STATE OF WASHINGTON  
DEPARTMENT OF ECOLOGY

November 8, 2006

Re: Wetlands issues for McIntosh gravel pit proposal

McINTOSH PONDS
 7820 SR 97
 Kittitas County, Washington

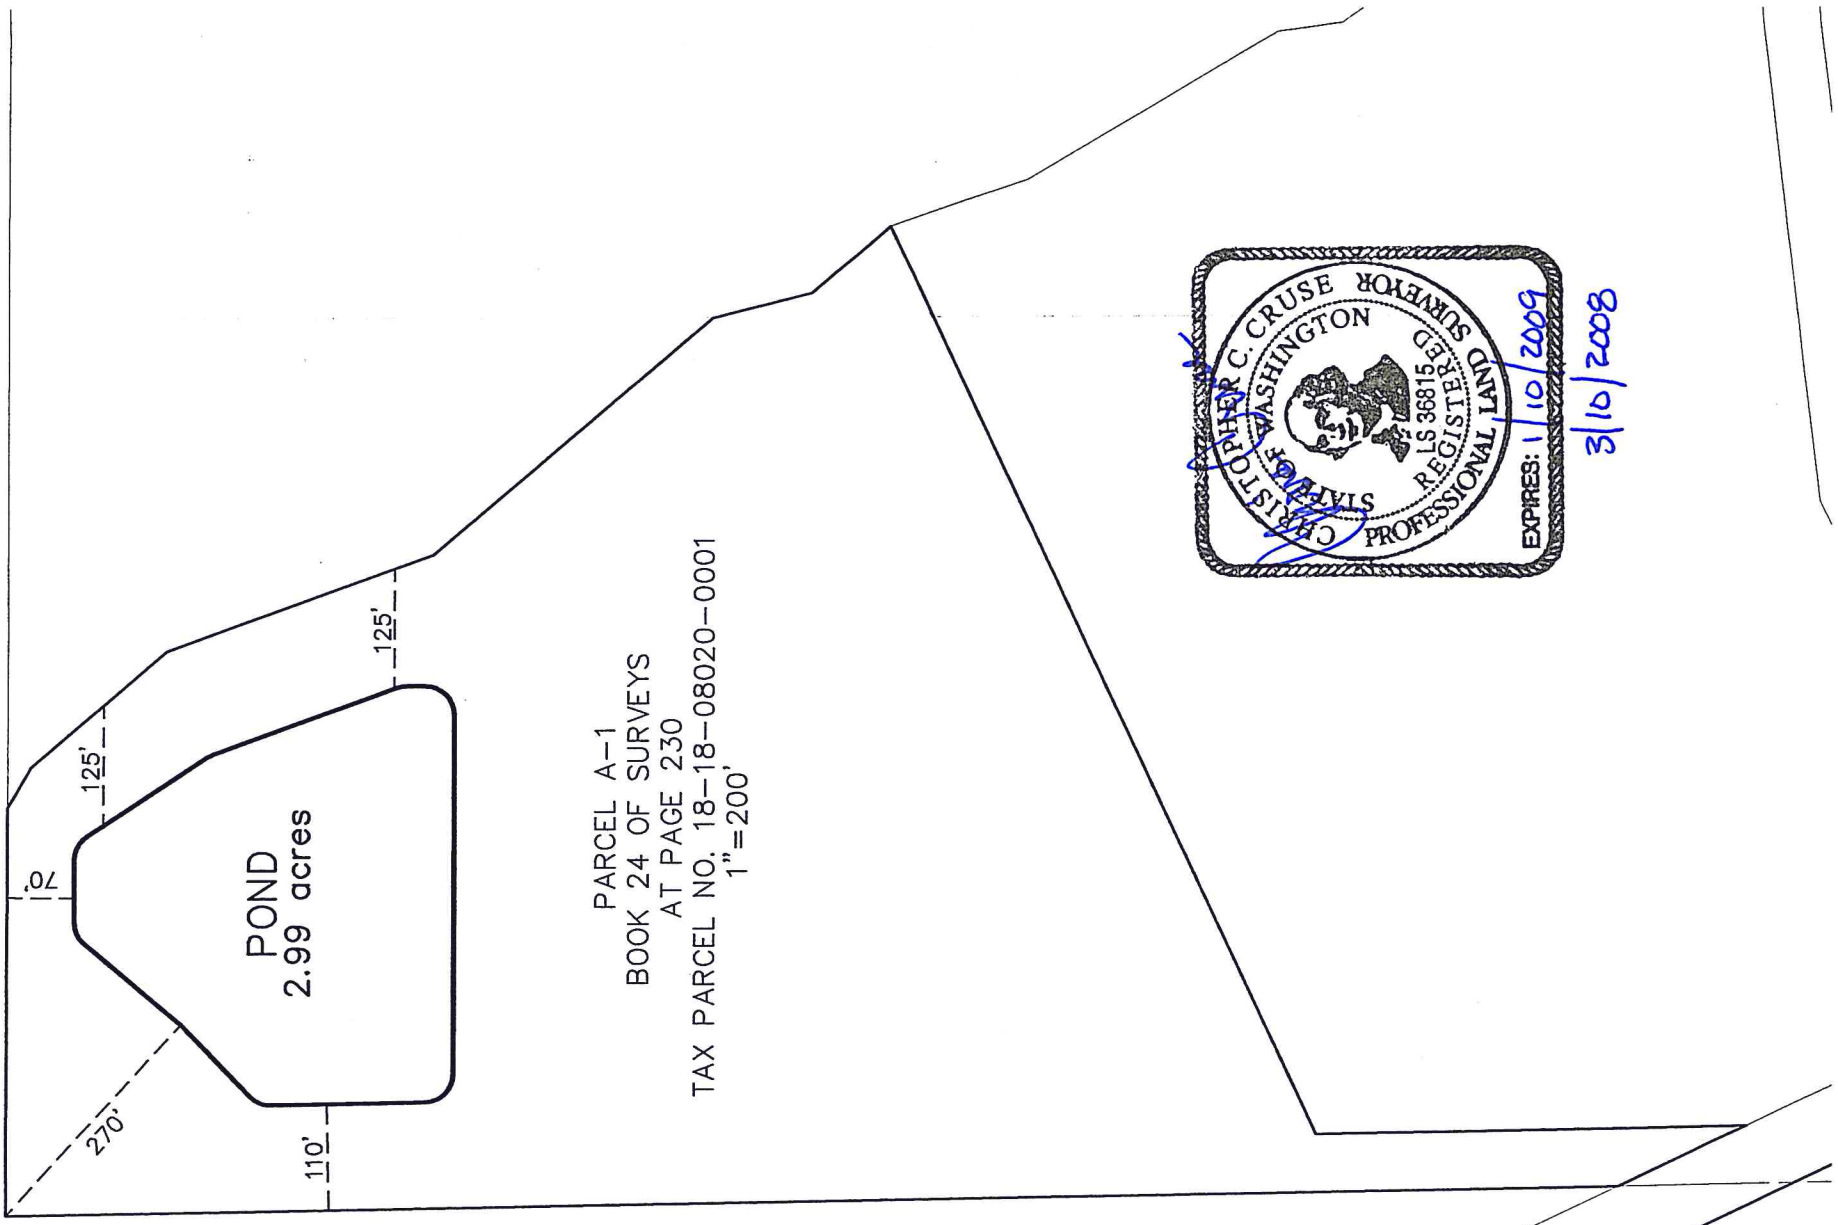
Parcel A3 contained what appeared to be a side channel of Dry Creek, running along the west side of the property and there was a broadened area of that channel which met the criteria for a wetland at the hole I dug upstream of its confluence with Dry Creek. I understand that irrigation water may be the primary source of water: however, if this side channel intercepts natural surface waters, groundwater or long term (10 to 14 days) of continuous flood waters, then the side channel would also be considered a jurisdictional wetland. There are wetlands associated with Dry Creek and its confluence with the side channel to the south of the proposed pond area on parcel A3. The distance between this feature and the side channel/wetland area should be marked on a map. As I recall, there was less than 50 feet between this area and the proposed pond. I understood from the applicant, however, that the pond edges could be adjusted to increase the buffer area.

Even though parcel A3 contained a wetland area, this area may be where mining should start, given that this area is more clearly understandable, uniform and the low spots are concentrated along the stream corridor. Of course, indirect impacts due to pit excavation need to be clearly understood to predict how much the wetland and Dry Creek corridor could be affected by the proposed mining project. The effect of avulsion of the pits into the Dry Creek system should also be discussed. A complete application should include all staging areas as well as anticipated protective buffers for known wetlands.
